RE: Response to Submissions and Amended Proposal Report - Powerhouse Parramatta State Significant Development SSD-10416

APPENDIX A – TECHNICAL FEEDBACK POWERHOUSE PARRAMATTA SSD-10416 (RESPONSE TO SUBMISSIONS AND AMENDED PROPOSAL REPORT)

Figure 3.07 - 1 in 100 Year Flooding

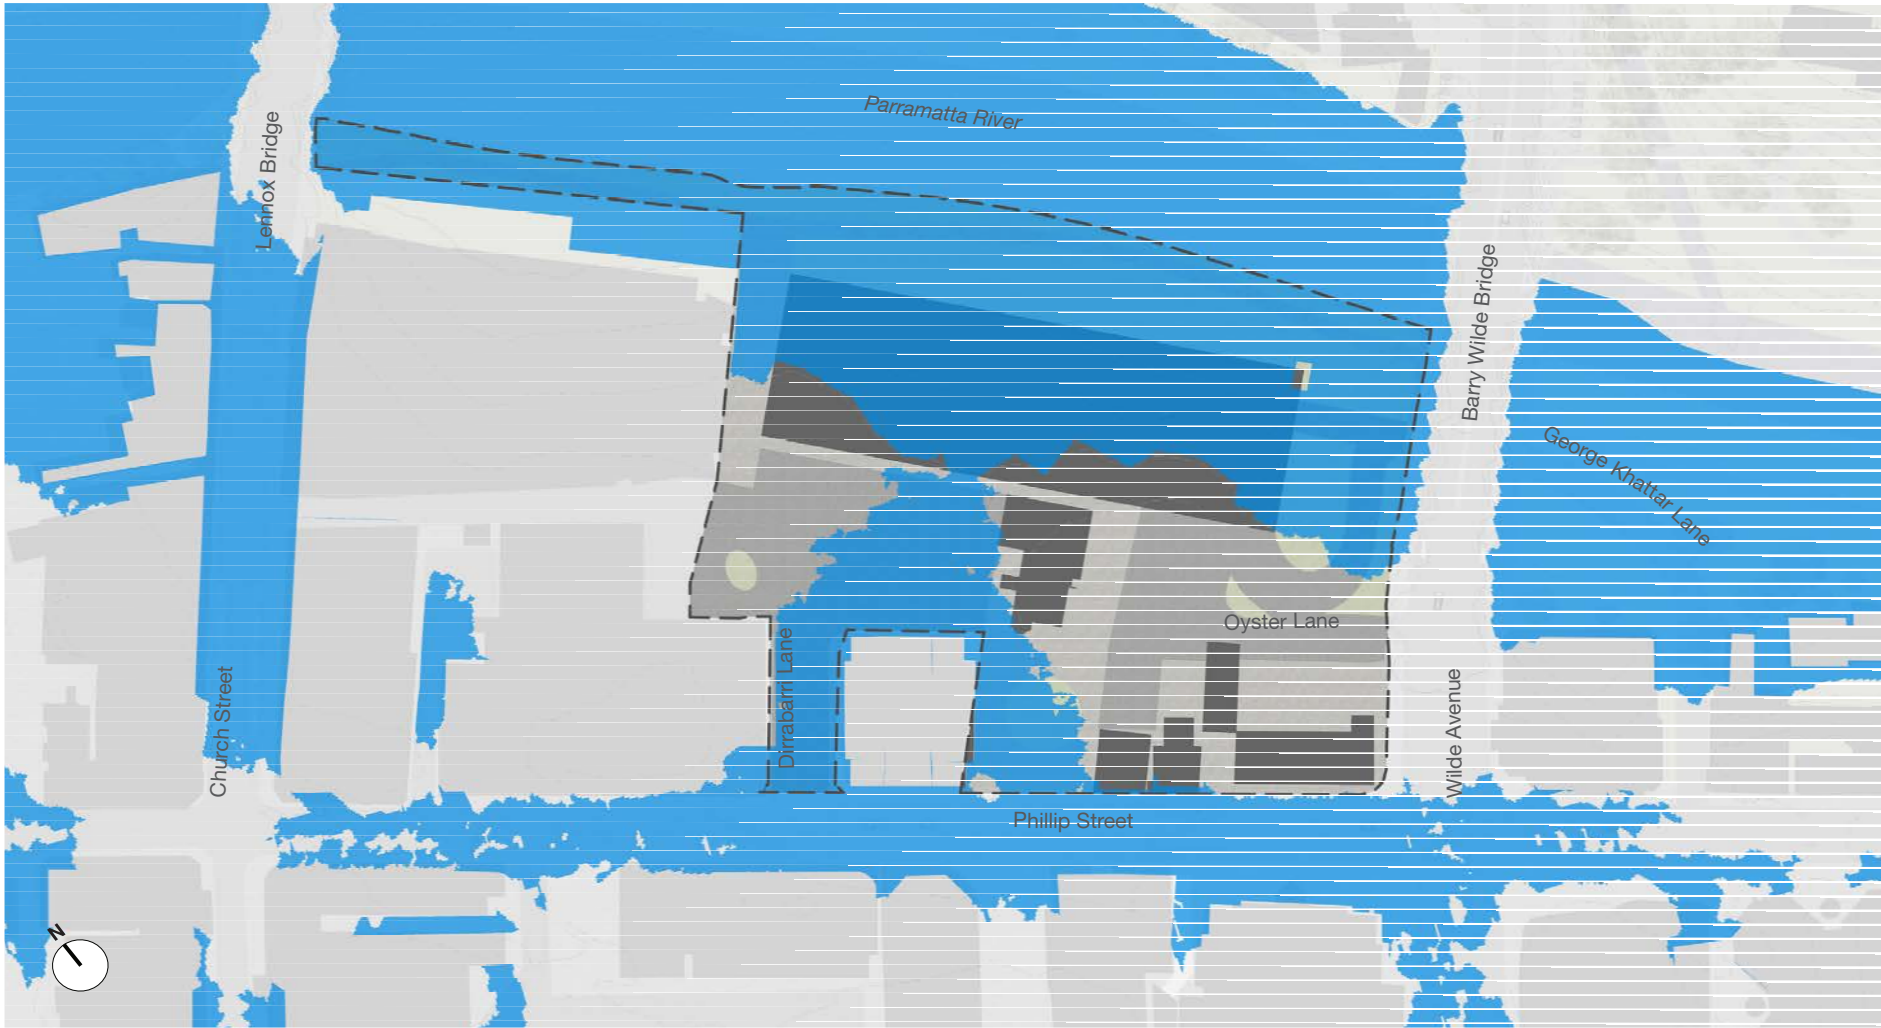
In relation to overland flow, once riverine flooding and conveyance has been resolved safely - by changing the built form and surrounding landform, it will also be necessary to re-examine the overland flow pathways across the site and how these affect useability, public safety and risk management.

A SECTION AA
Scale 1:200

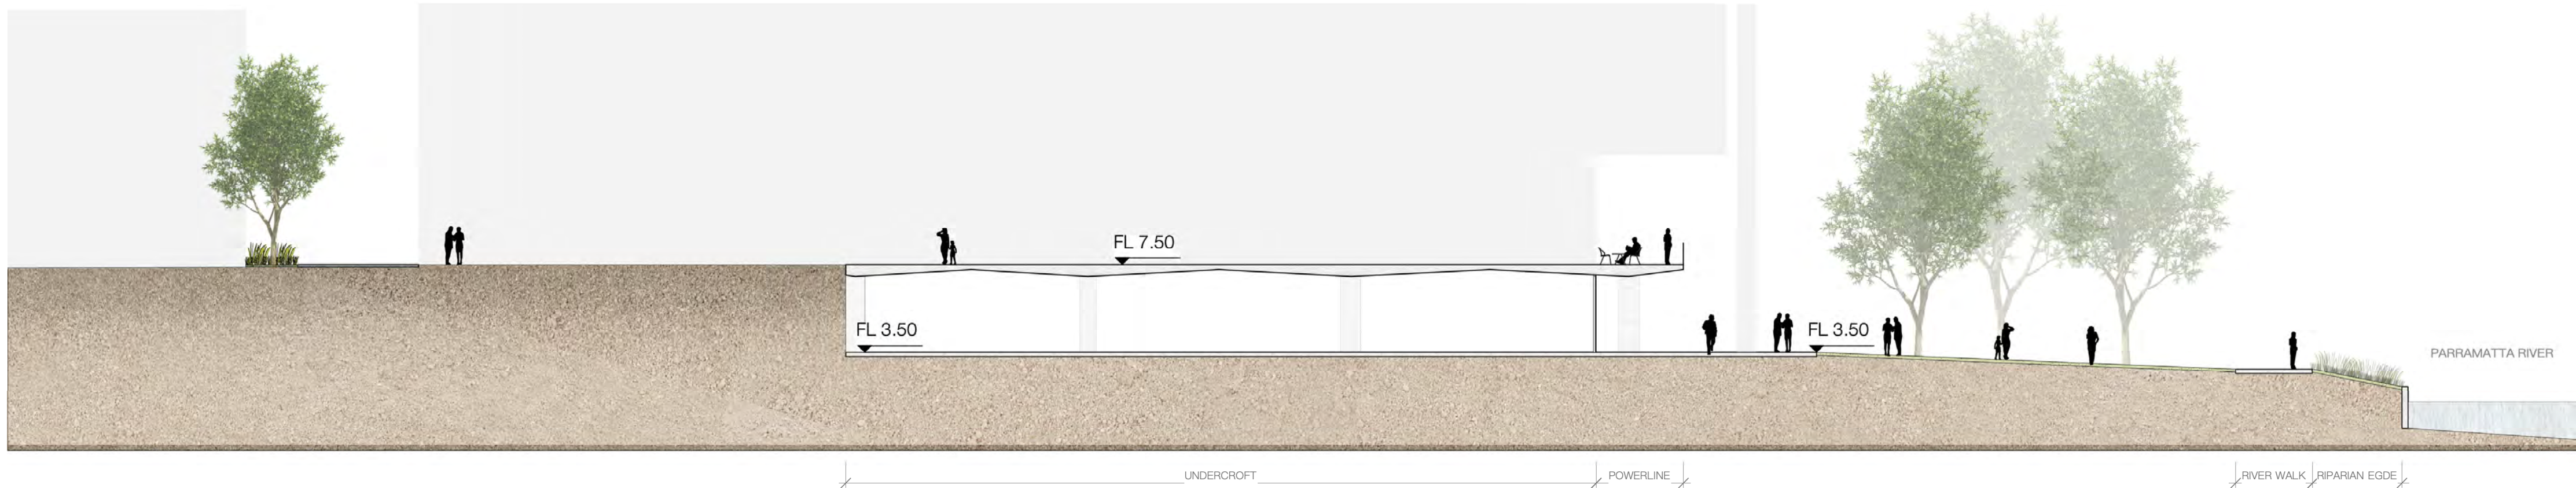
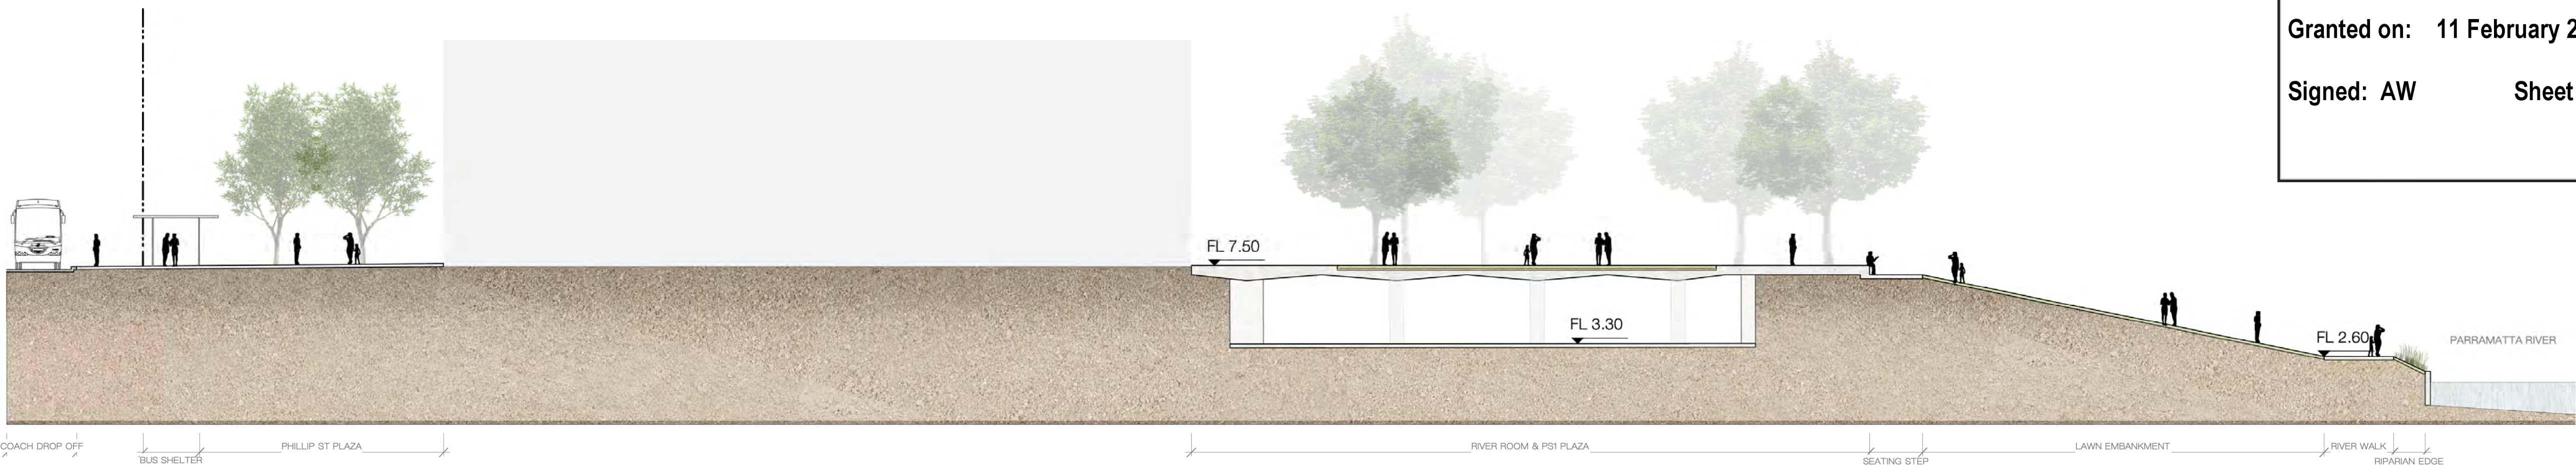
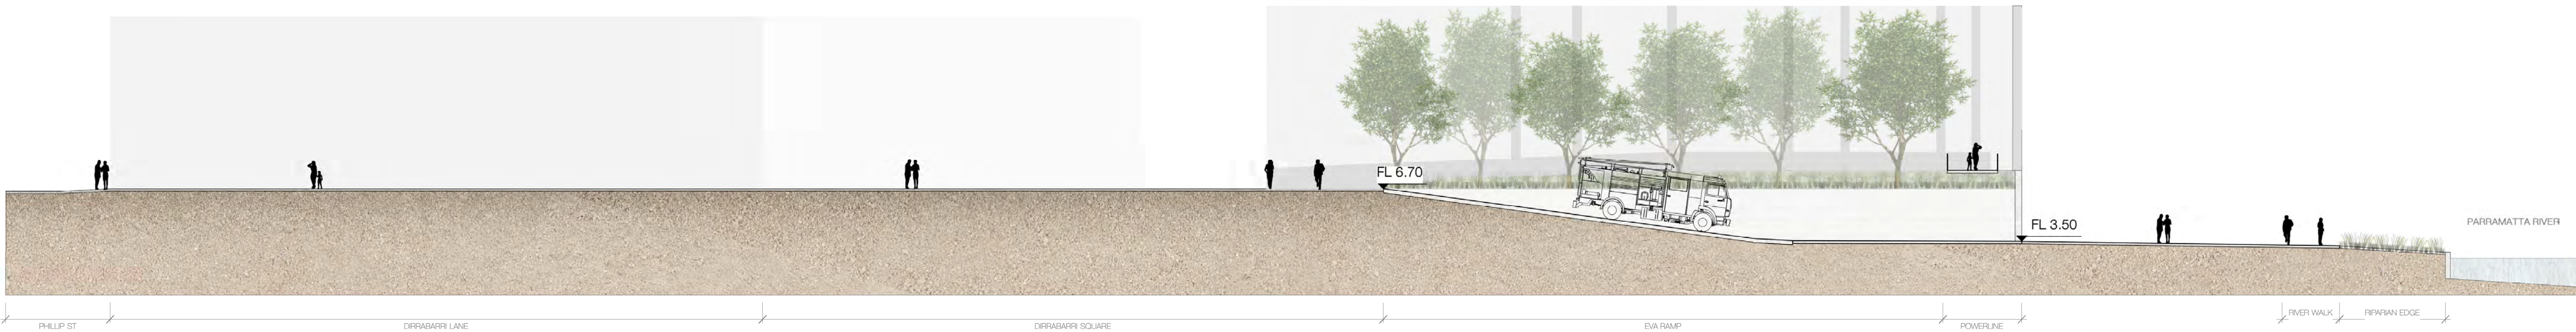
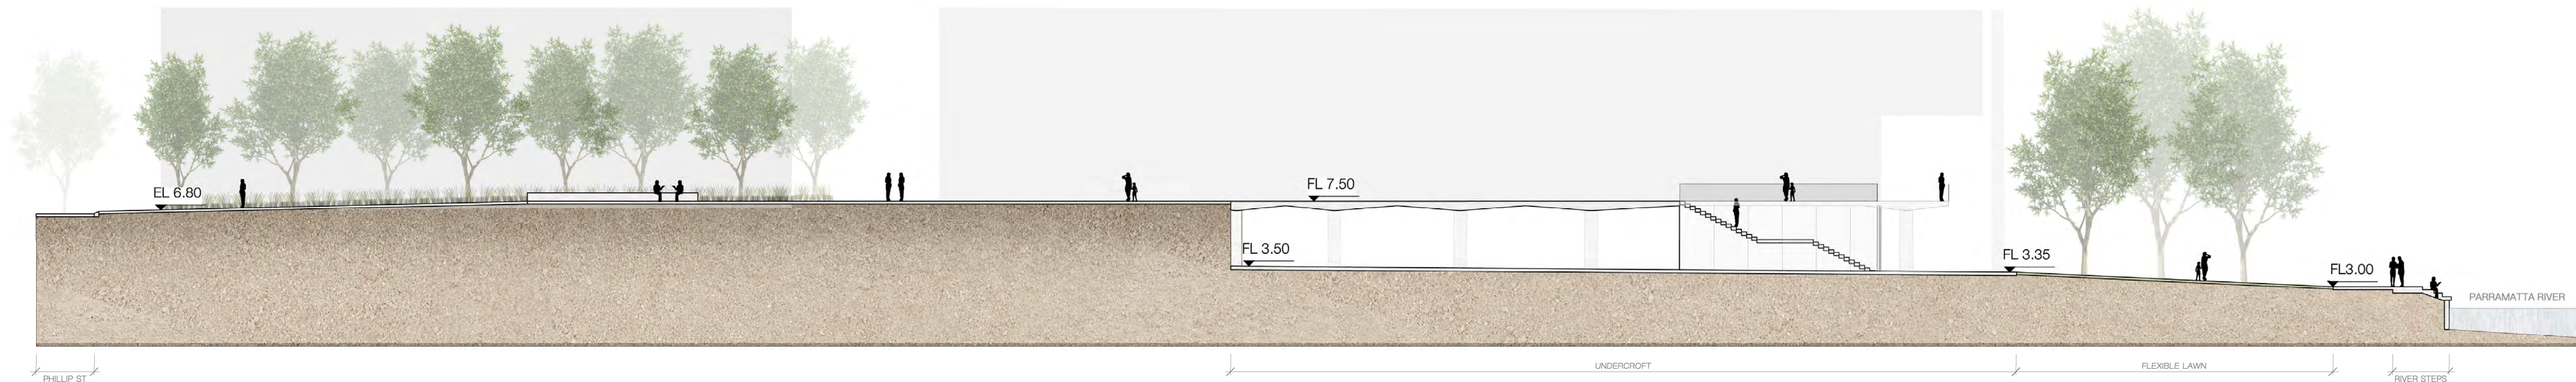
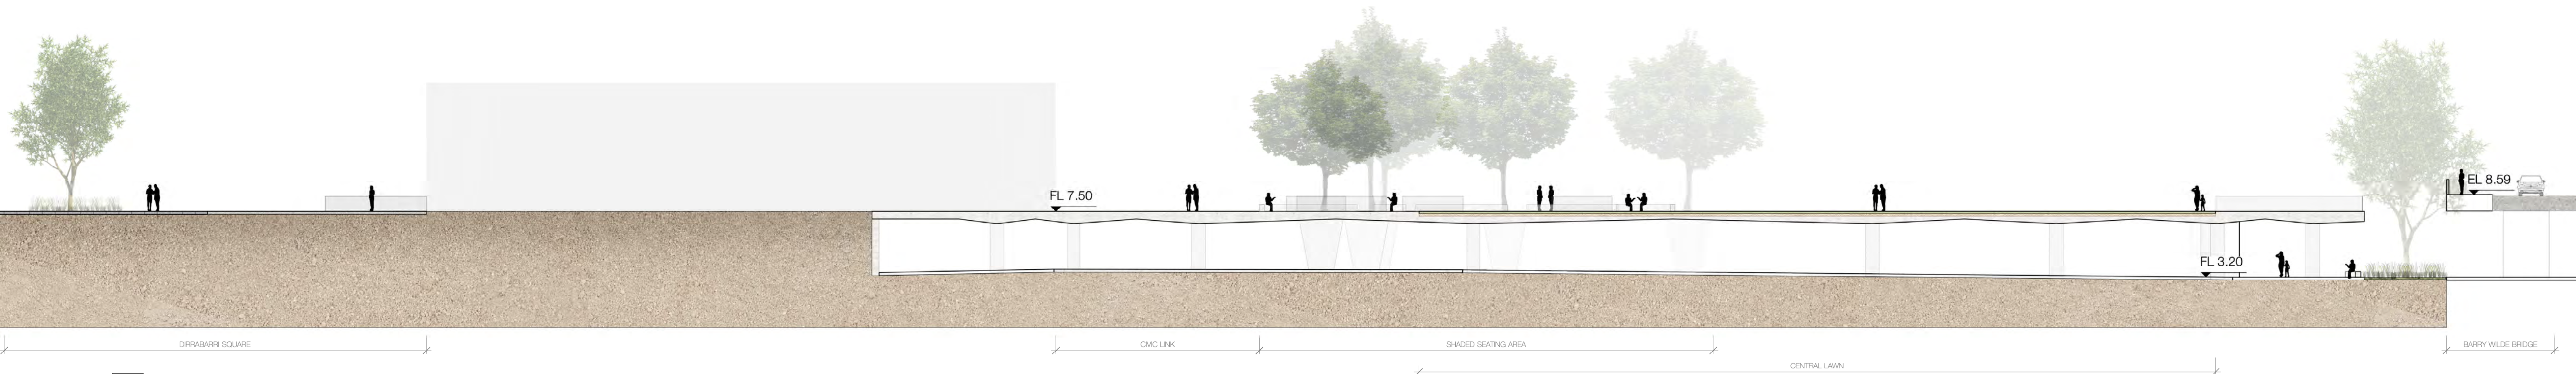
While Council acknowledges that the undercroft space will have limited access by the public through the erection of moveable screens managed by the Powerhouse, Council maintains its concerns regarding the suitability of the undercroft as a flood solution where the conveyance of floodwater through the undercroft also passes through proposed habitable floor space. This is due to the potential threat to life, property and critical building services in a flood event (including evacuation via a single, limited capacity lift, which provides critical access to mobility impaired). Council considers this to be in contradiction of the Floodplain Development Manual and NSW Flood Policy. This space will have a level floor and the 1% AEP (100 year) floodwaters will flow with substantial velocity 2-3m deep extending to the back wall of this structure.

In this regard, Council reiterates its earlier recommendation that the undercroft be removed from the design. It also recommends the undercroft be replaced with a suitable sloping riverbank section that may be a viable solution to manage the conveyance of floodwater. This would also have the added benefit of creating a more integrated foreshore landscape interface where the 'natural' sloping riverbank profiles that existed before the existing car park was originally constructed (and which appear to be still visible on site) could be considered as the baseline for predevelopment conveyance capacity and afflux considerations.

Related to the undercroft and flooding, is the public domain response. The proposal includes an extensive podium that acts as a cover to the undercroft, separating the museum from the river foreshore and dividing the space into two disconnected spaces. This results in a podium landscape which is constrained in its ability to deliver an integrated flood conveyance solution. Council understands that the purpose of the podium landscape relates to museum programming in the external space, including potential exclusive use periods with fencing and ticketing dividing the site.

If the undercroft was removed, Council sees an opportunity to redesign the interface between the buildings and the surrounding public space, replacing significant vertical transition with a sloped or terraced landscape form more reminiscent of the competition scheme. This approach is likely to improve connections between the Museum and river foreshore, and provides opportunities for a range of civic events more in keeping with River Square public space envisioned in Parramatta City River Strategy.
